**Consultation Response from KC,
Highways Development Management****2025/91121 St Marys Vicarage, Spen Lane, Gomersal, Cleckheaton, BD19 4LS****Demolition of existing vicarage and erection of 10 apartments****Date Responded: 19/11/2025****Responding Officer: D. Stainsby****Responding Ref: K9-9NE/7**

This application is for the demolition of existing vicarage and erection of 10 apartments at St Marys Vicarage, Spen Lane, Gomersal.

| DRAWING NUMBER:<br>415.064946.00001-D100 |                |                  | REVISION:              |

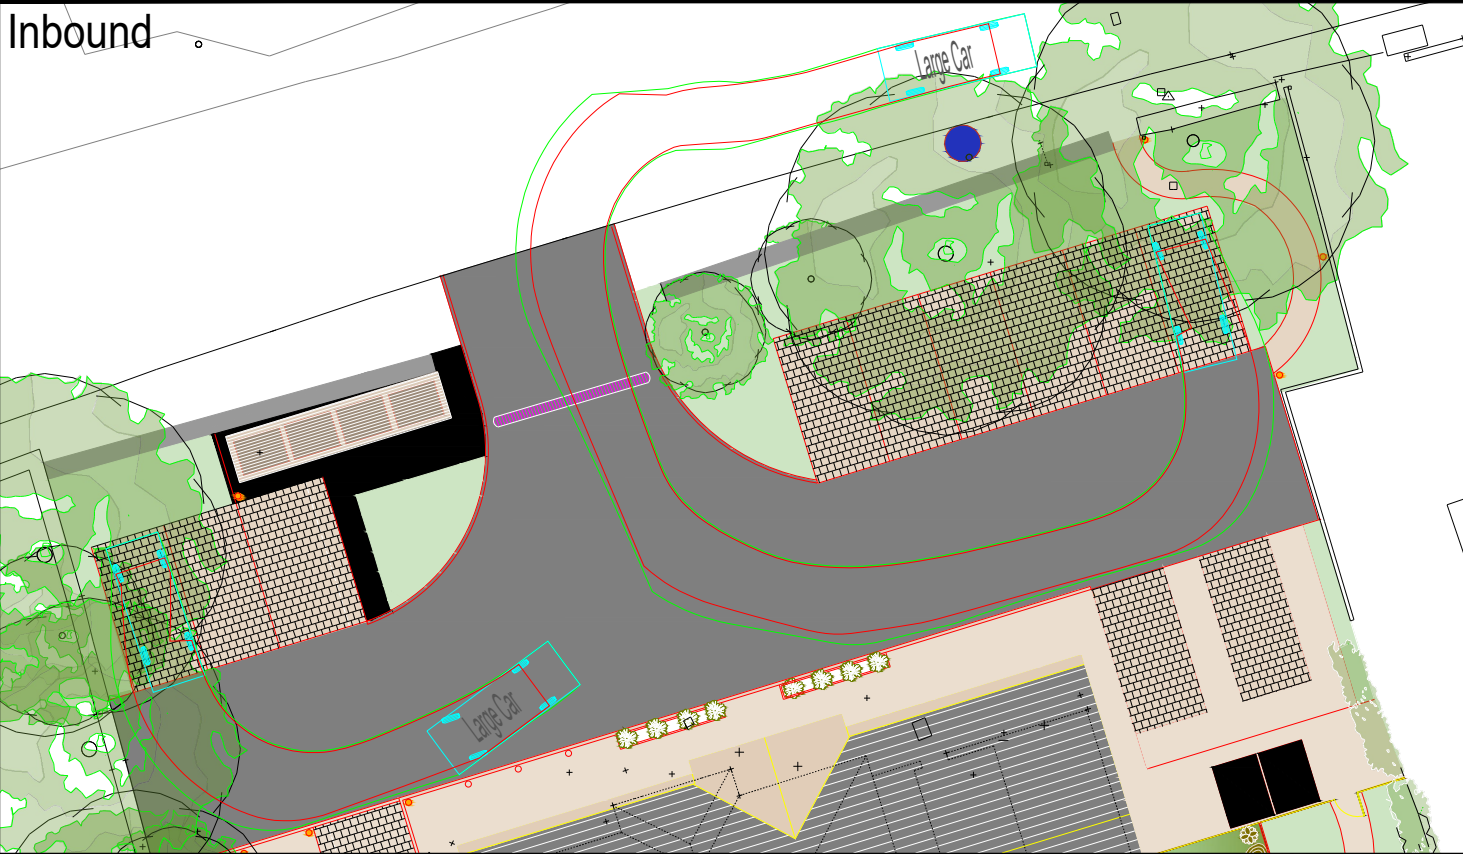
A643 Spen Lane is subject to a 30mph speed limit at this location and sight lines of 2.4m x 43m have been proposed for the vehicle access which meets the requirements The wall is also proposed to be reduced in height to achieve the sightlines.

The Applicant has submitted drawing no. 415.064946.00001-D100 Rev. showing the sightlines.

DRAWING NUMBER: 415.064946.00001-TR100

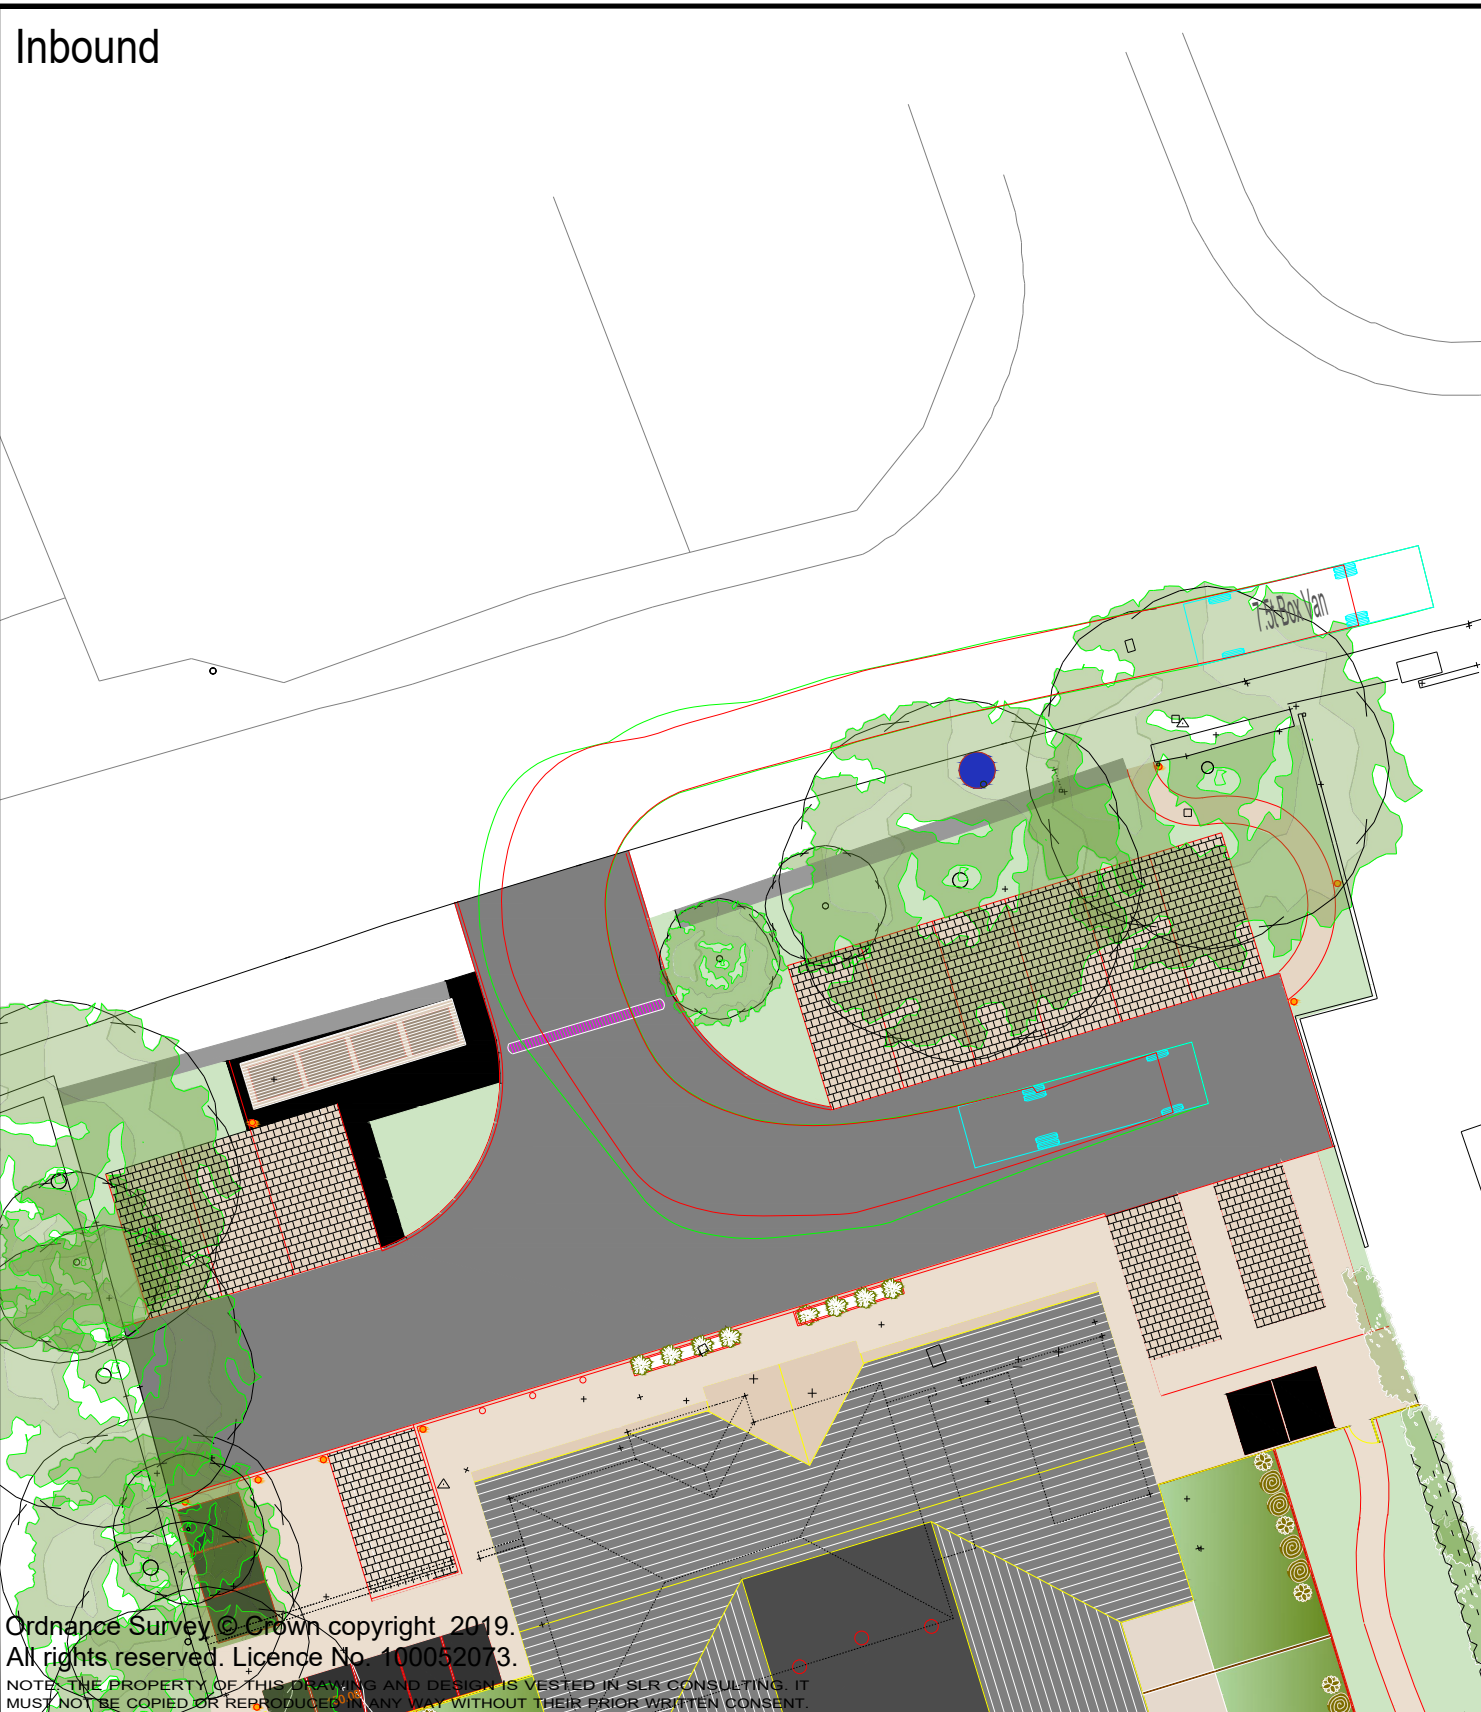
11 car parking spaces are proposed. 1 per flat and a visitor space and internal turning to allow vehicles to access and exit the site in forward gear is proposed and is acceptable.
